Application No: AW/353/20/OUT
Site Address: Land adjacent to 1 Cambridge Walk Aldwick PO21 5RL
Description of works: Outline application with some matters reserved for 1 No. new dwelling.

Thank you for your internet representation made on 2nd March 2021 which has been recorded as an objection with the comments as follows:

Site Plan shows area bounded by: 491668.61, 99621.47 491810.03, 99762.89 (at a scale of 1:1250), OSGridRef: SZ91739969. The representation of a road, track or path is no evidence of a right of way. The representation of features as lines is no evidence of a property boundary.

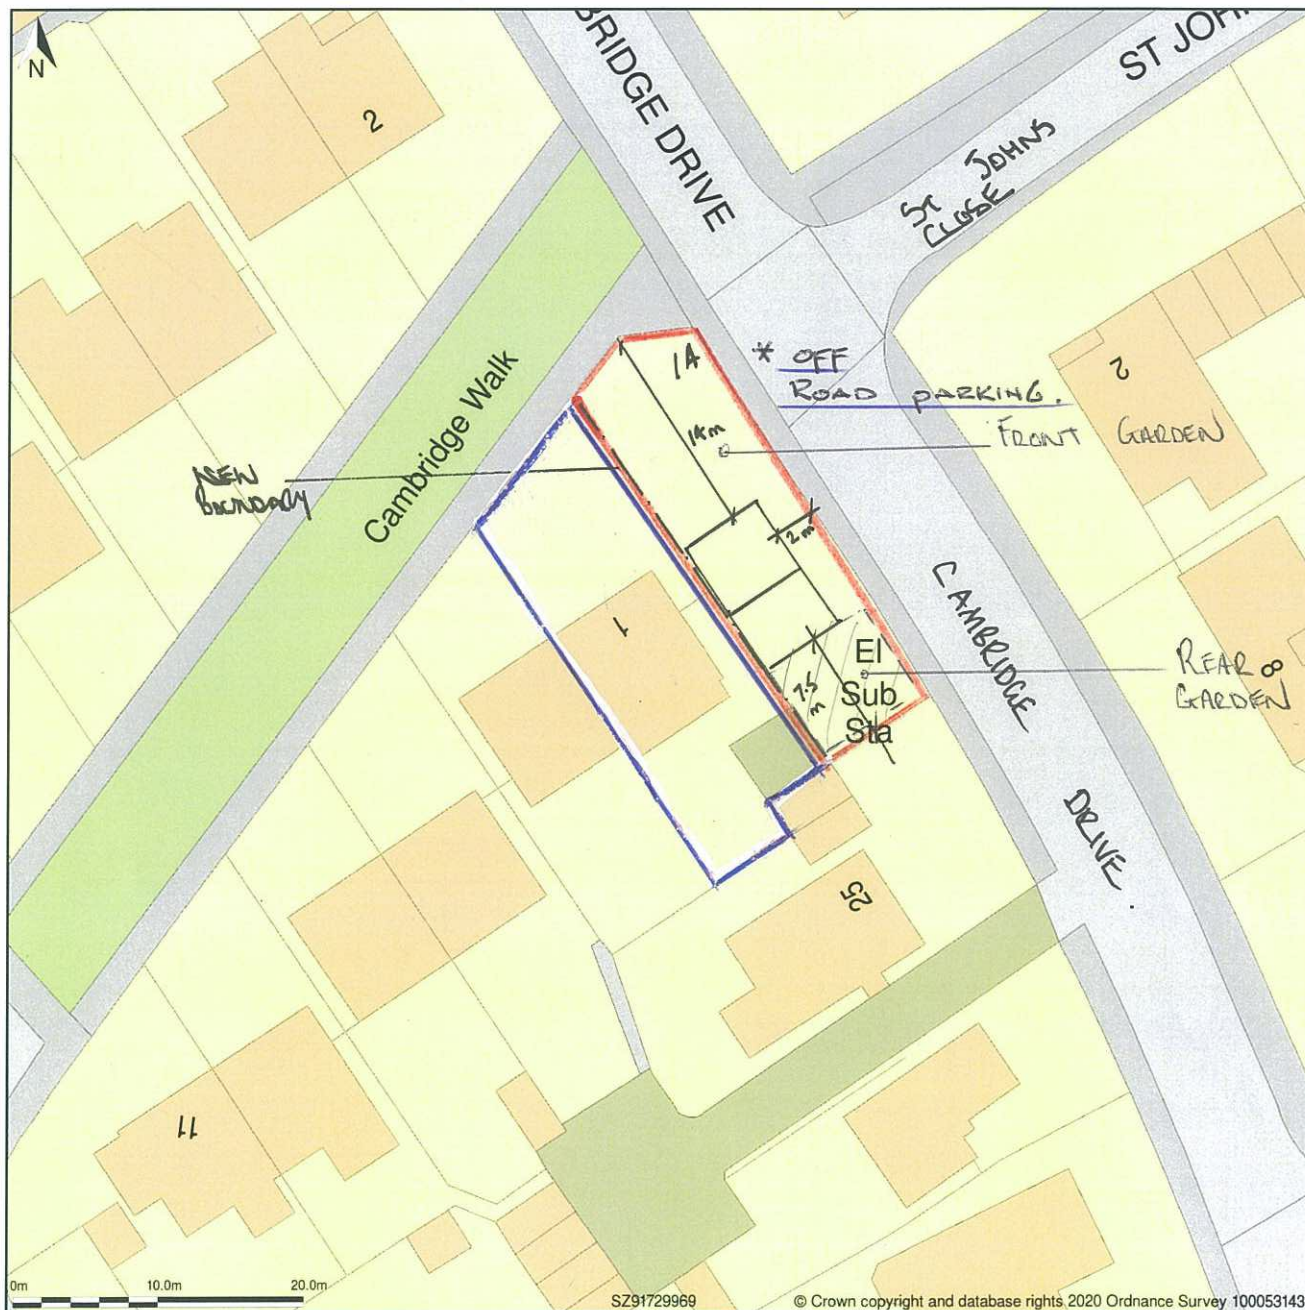
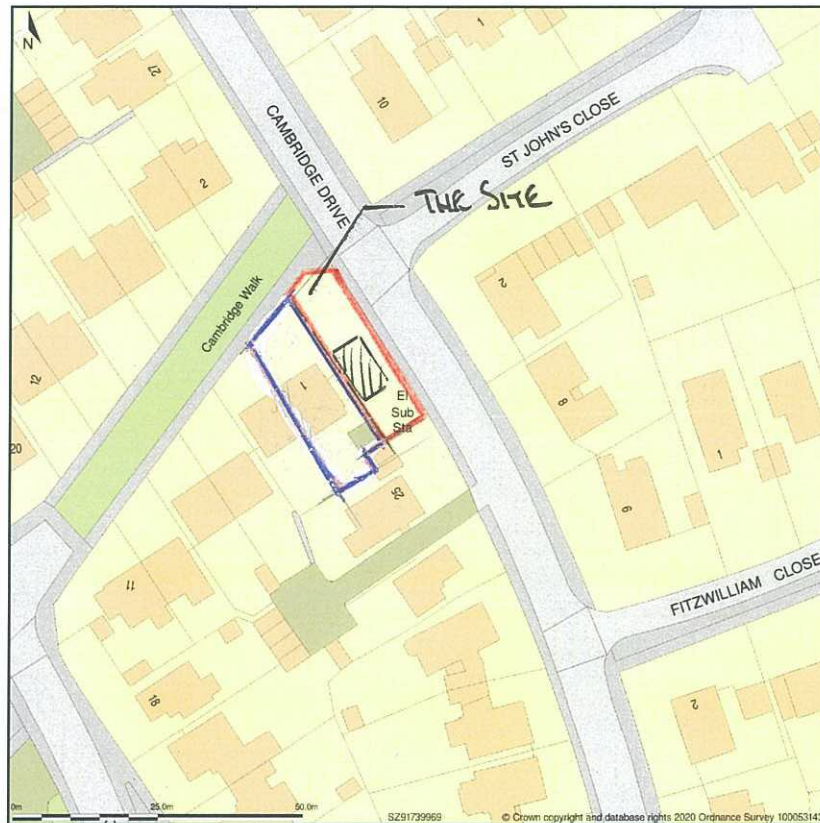
Members strongly objected to the application on the grounds that this is an open plan area and the application therefore does not reflect the characteristics of the site and local area in its layout, landscaping or character. Members referred to the fence that is shown on the application and to the fact that the proposed building protrudes beyond the building line and onto the open area on Cambridge Drive. Members were further confused by the reference to a total of 4 residential units on the application. Therefore Members agreed that the application is in direct conflict with Policy DSP1 of the Arun Local Plan 2011-# 31 and with the Parish Design Statement P 71.
